CITY OF ALBUQUERQUE
PLANNING DEPARTMENT
LAND DEVELOPMENT COORDINATION DIVISION

4. Project # 1002318
02DRB-01649 Major-Bulk Land Variance
02DRB-01656 Minor-Prelim&Final Plat Approval

Re: Preliminary Plat – Tracts OS-2, OS-3 & Tract 13, High Desert
DRB Project # 1002318; 02DRB-01649 Major-Bulk Land Variance; 02DRB-01656 Minor-Preliminary &
Final Plat Approval

DEVELOPMENT REVIEW BOARD
November 20, 2002
Project # 1002318

**BULK PLAT OF
 TRACTS 13-A, 13-B, 13-C,
 OS-2-A & OS-3-A
 HIGH DESERT**
 (A REPLAT OF TRACTS 13, OS-2 & OS-3,
 HIGH DESERT)
 ALBUQUERQUE, NEW MEXICO
 DECEMBER, 2002

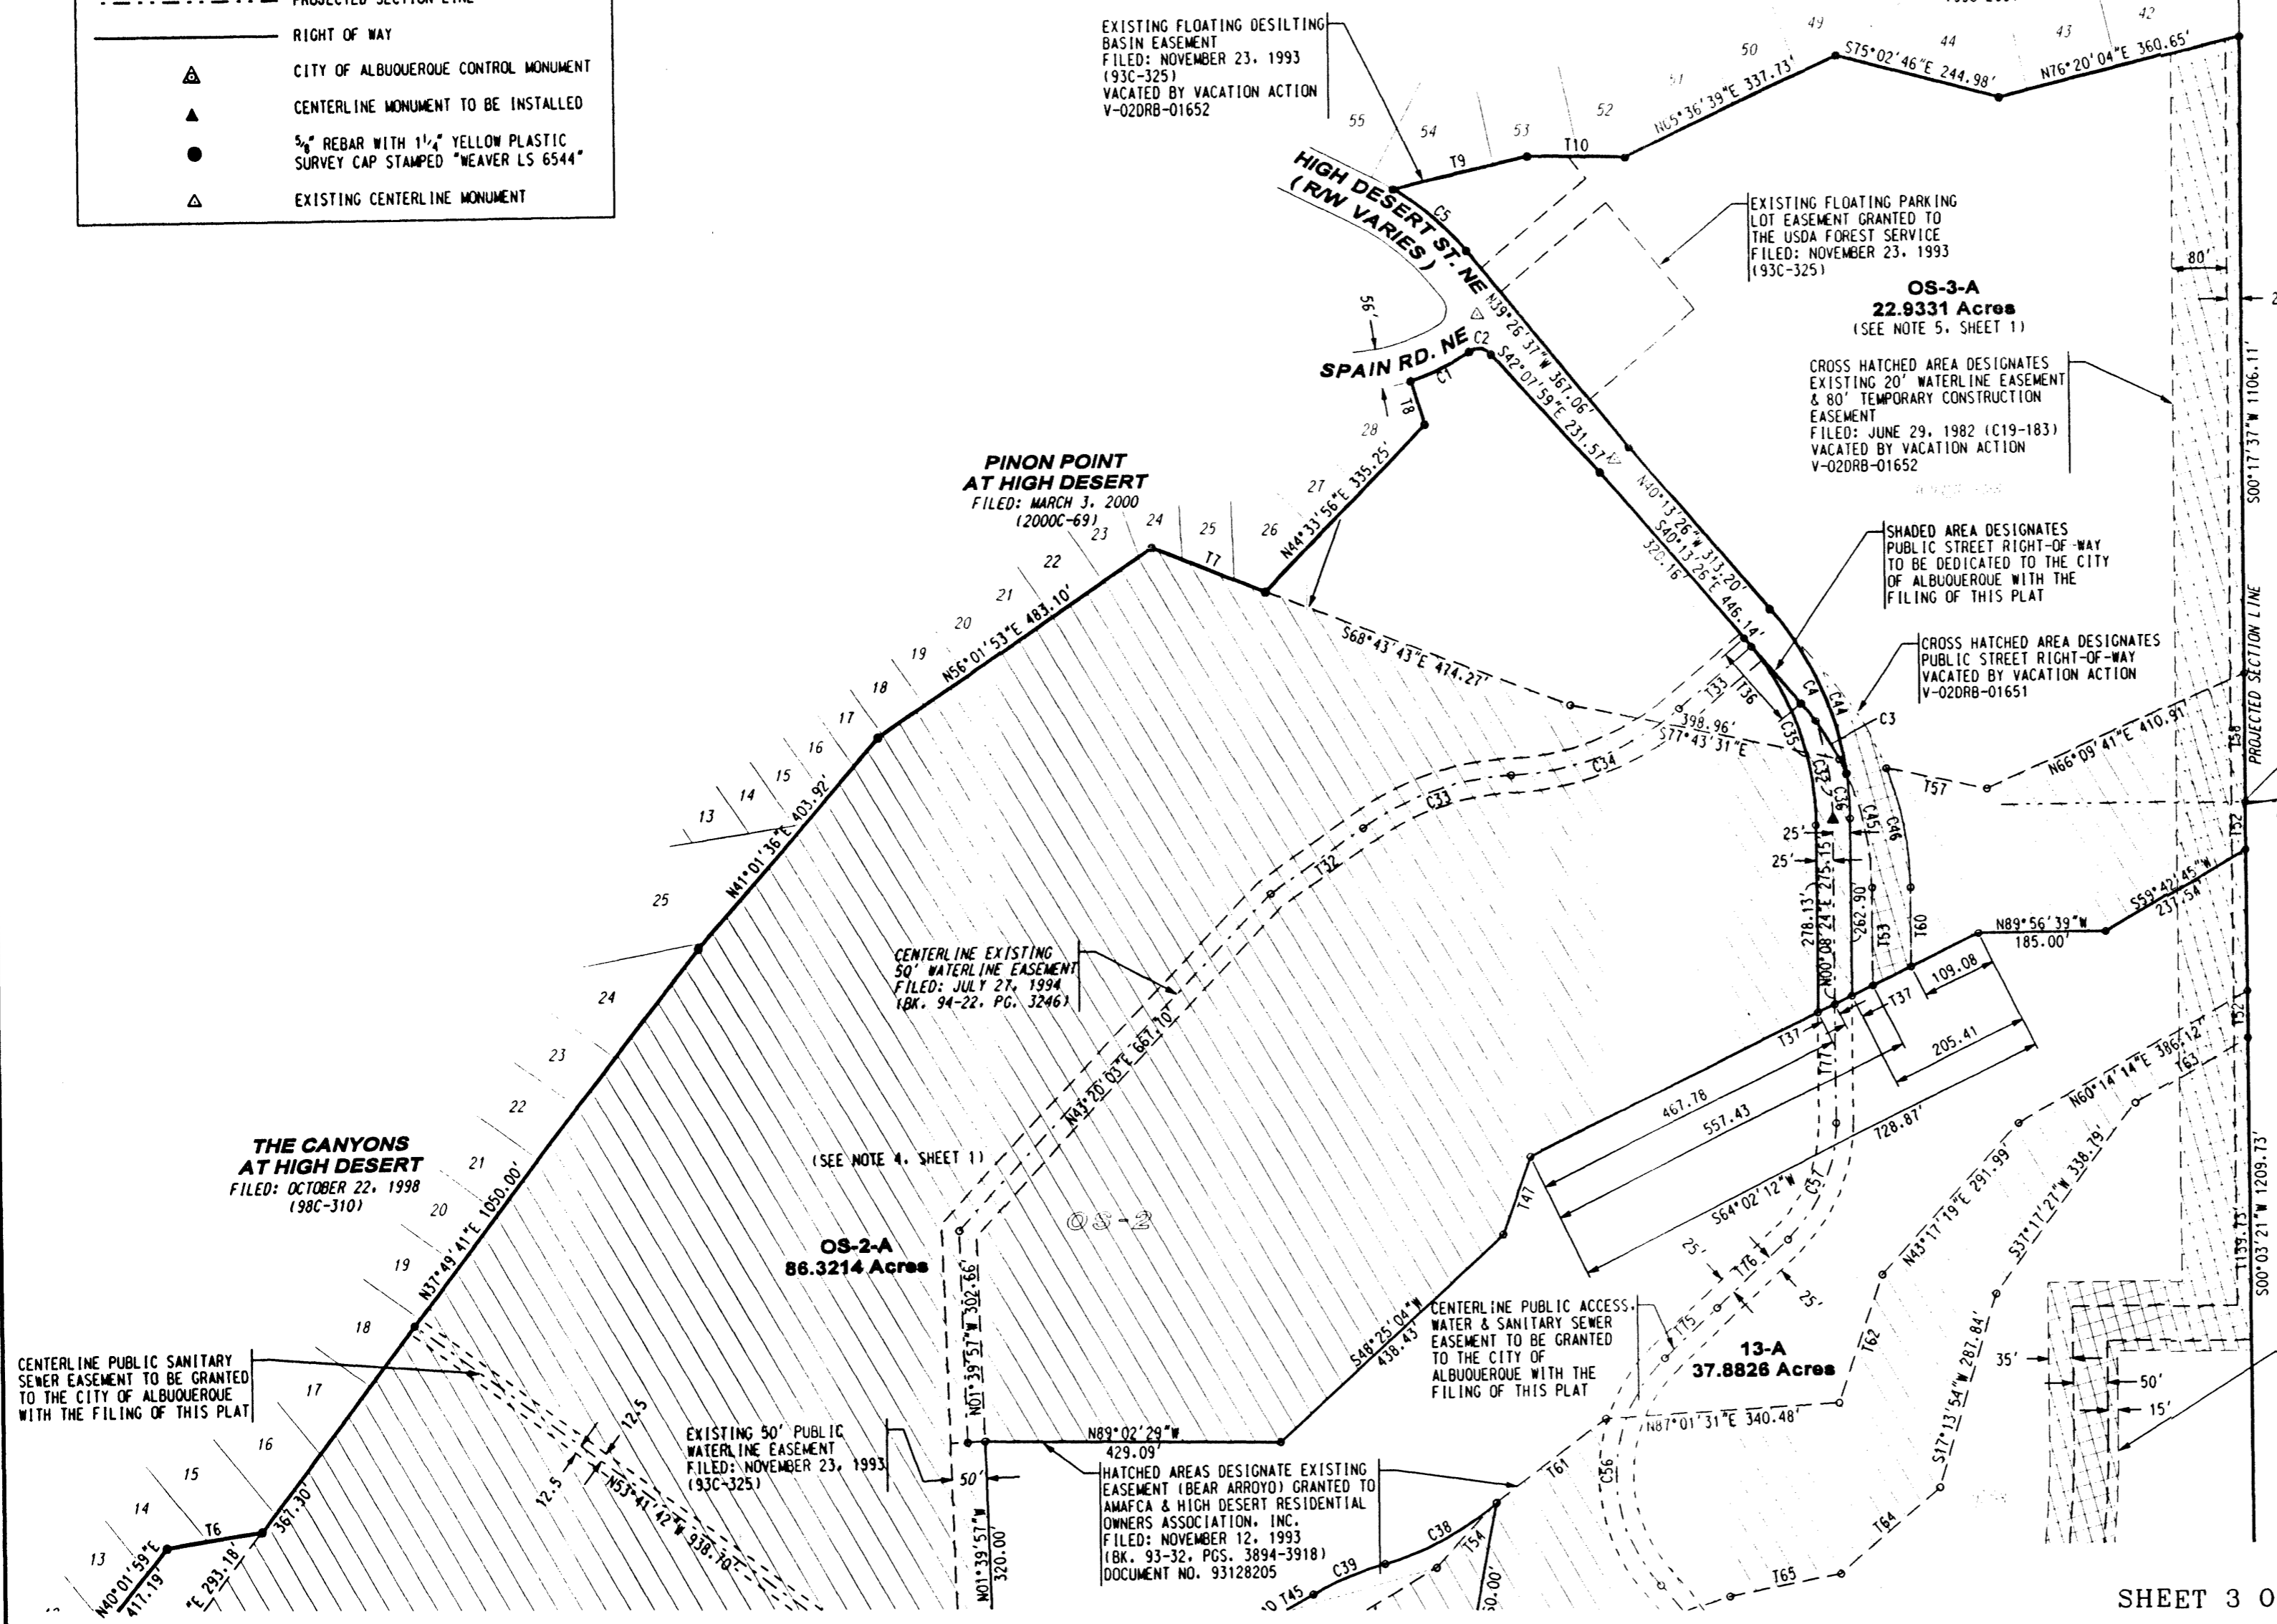
The preliminary plat has been revised to remove note 30 which references the vacation of the existing AMAFCA easements. The AMAFCA easements indicated in note 30 will be vacated with the subdivision platting action for Units 1, 2 and 3 of the Wilderness Subdivision at High Desert. The preliminary plat for Units 1, 2 and 3 of the Wilderness Subdivision at High Desert is also being heard at DRB on Wednesday, November 20, 2002 (DRB Project # 1002315). The remaining vacations (public right-of-way, public waterline and desilting basin easements) will be vacated and shown on the "Bulk Land" Plat.

The planning department indicated that Map 11 in the High Desert Sector Plan shows a pedestrian trail within the boundaries of the bulk land variance and that the bulk land exhibit submitted does not clearly indicate where this trail would be located. The trail location is not required to be shown or located with the bulk land plat but instead has been shown on the preliminary plat for the Subdivision (DRB Project # 1002315). A trail will be located along the east side of the High Desert Place as is indicated on the infrastructure list. Planning also indicated that the legend did not clearly show the difference between property line and proposed right-of-way line. The legend along with the existing notes provided on the enclosed revised "Bulk Land" preliminary plat help identify the right-of-way lines and property lines.

1. Map 11 in the High Desert Sector Plan shows a pedestrian trail within the boundaries of the bulk land variance. The bulk land variance exhibit submitted does not clearly indicate where this trail would be.
2. The legend does not clearly show the difference between a proposed property line & a proposed right of way line. There are many similar lines on the exhibit.
